Department of Primary Industries

OUT16/17235

Bourke Small Stock Abattoir (SSD 7268) Comment on the Environmental Impact Statement

WASTE WATER TREATMENT FACILITY
SCALE 1:1000

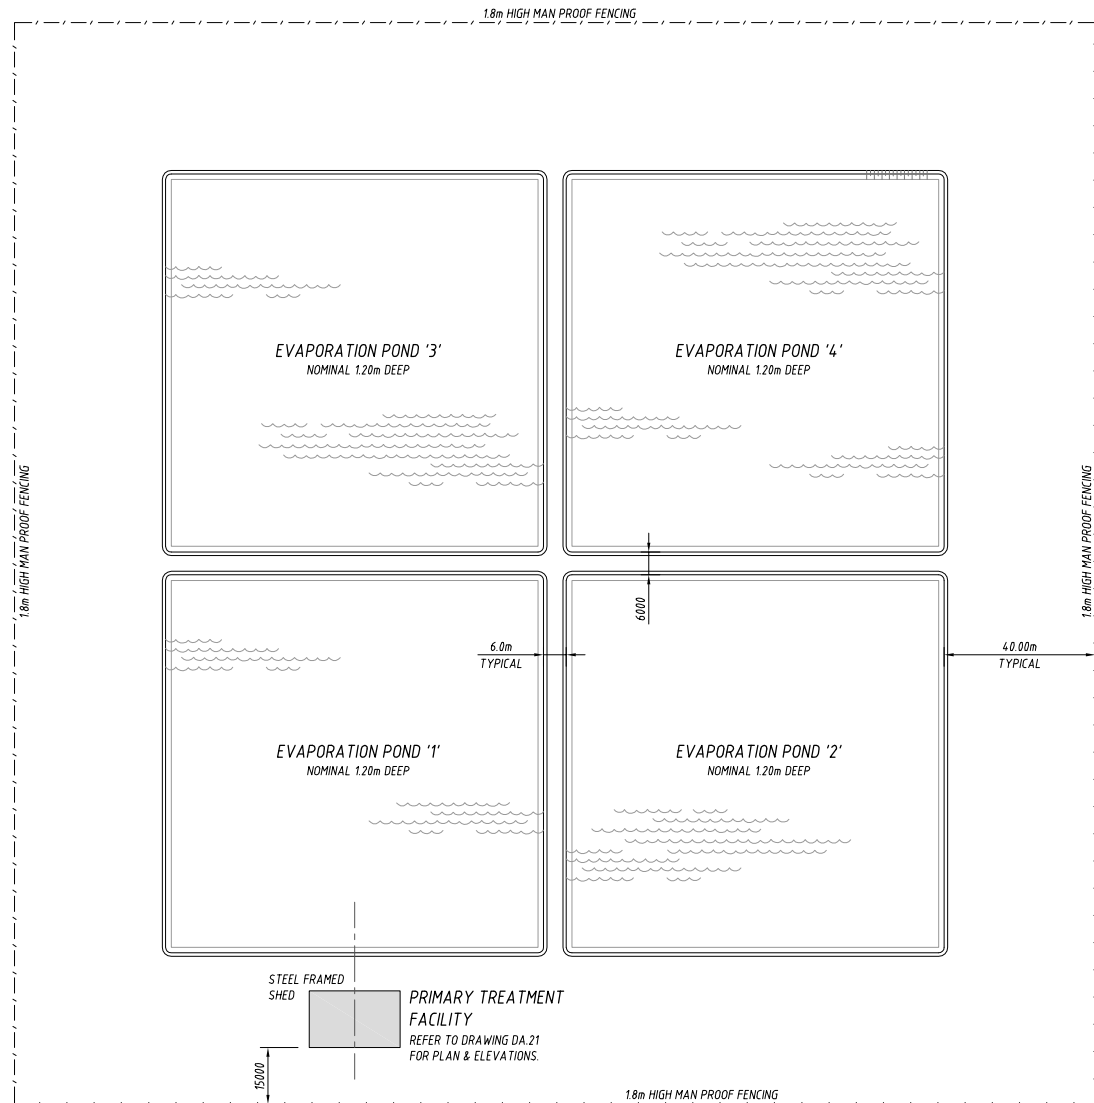
- The EIS indicates wastewater is to be produced at the rate of 0.7ML/d and is to be treated via a series of four treatment ponds. Each pond is to have a 12ML capacity (60m x 60m and 3-4m deep) and is to be lined with a 1mm synthetic liner to mitigate seepage into the underlying soil and groundwater. Based on no groundwater being intercepted in the soil cores drilled to 8.8m, groundwater is not predicted to be intercepted during pond construction.

- Two groundwater monitoring bores are proposed to monitor potential impacts from the wastewater treatment ponds. This concept is supported, however no detail is provided of bore construction, monitoring frequency and the suite of analytes to be monitored. DPI Water recommends this be addressed prior to commencement of the project.

- Prior to commencement of the project DPI Water recommends the following:
 - o Drill two monitoring bores to intercept the water table in the Upper Darling Alluvial Groundwater Source or to a minimum depth of 20 m below ground level to establish groundwater level and baseline groundwater quality. Complete an assessment of the impact of the development against the minimal impact considerations in the NSW Aquifer Interference Policy.
 - o The proponent in consultation with DPI Water identify the location and timing of the proposed two monitoring bores, depth, slot intervals, monitoring frequency and suites of analytes to be monitored, and development of a mitigation plan in the unlikely event of adverse impact on the groundwater source.
